## Application for a Non-Material Amendment Following a Grant of Planning Permission

Demolition of existing garage, proposed two storey side extension and single storey rear extension

22/02219/FUL

Change Juliette doors to window on Rear Elevation of new extension

Status	Date	Scale	Project No.	Drawing No.	Rev.
Planning	Oct 22	1:100 @A3	22-443	PL- 22-443-05	G

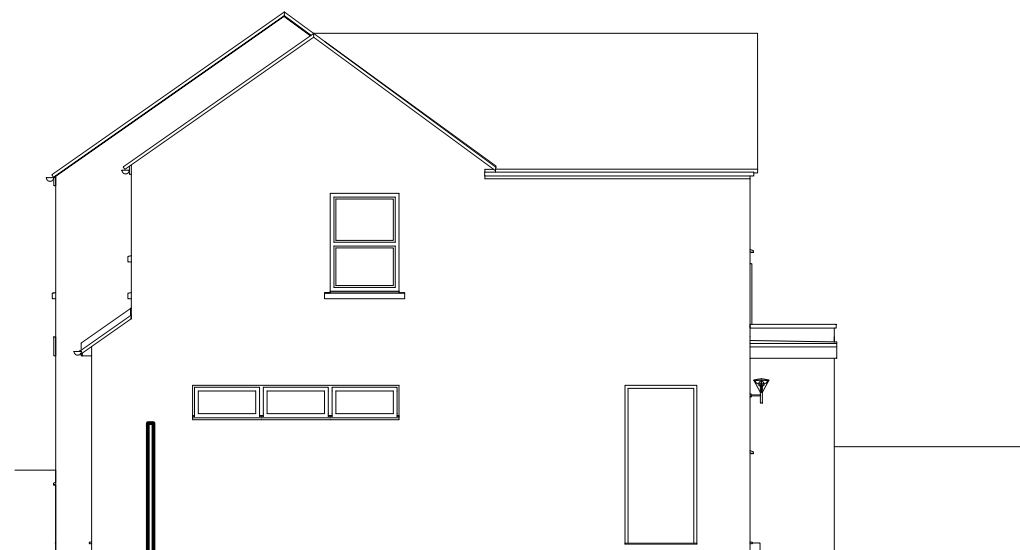
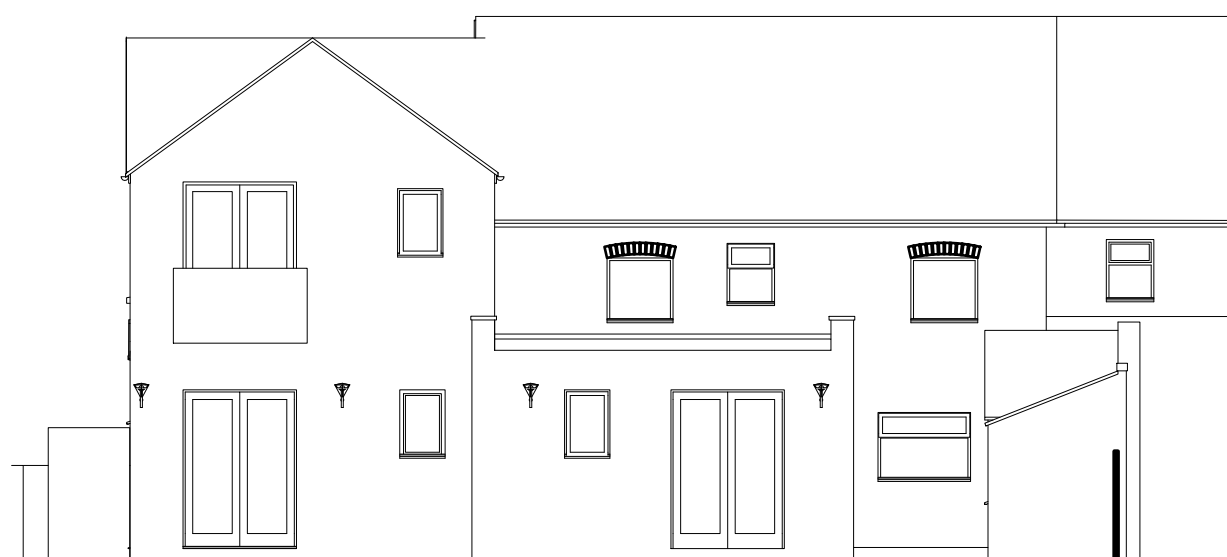
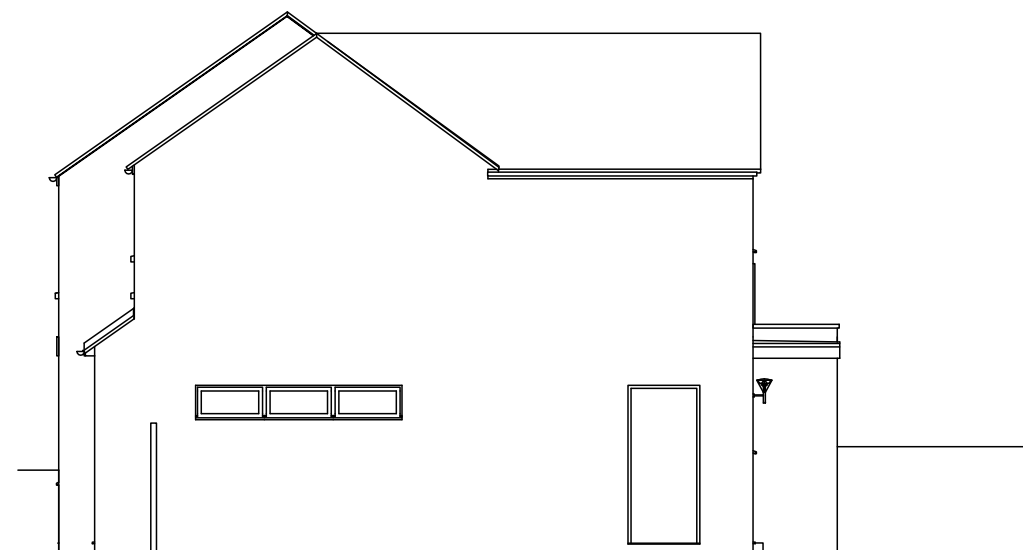
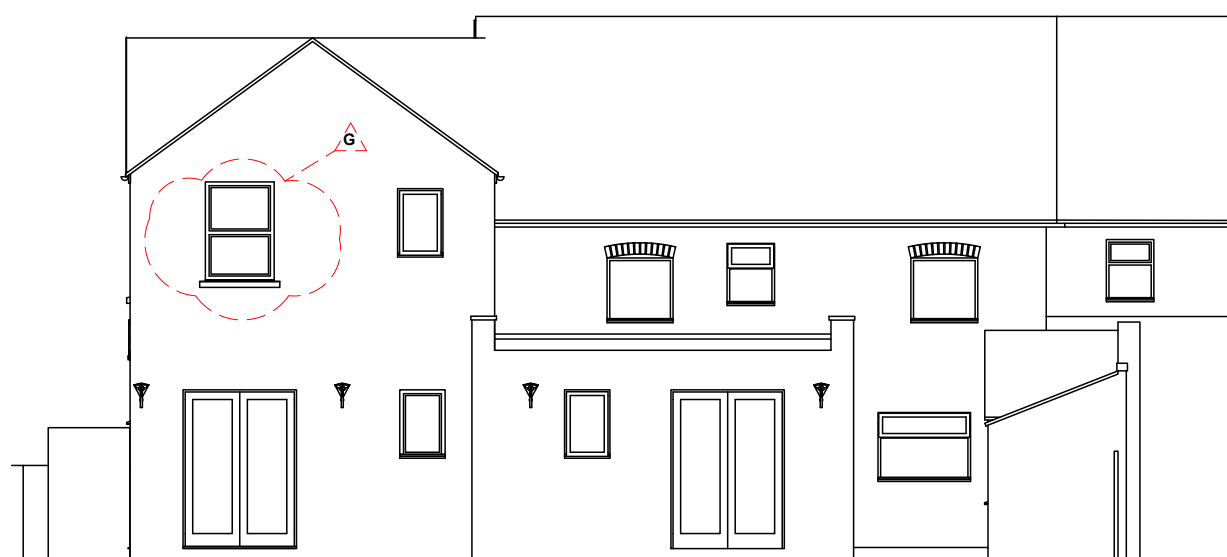
PL- 22-443-04G and PL- 22-443-05E

PL- 22-443-04J and PL- 22-443-05G
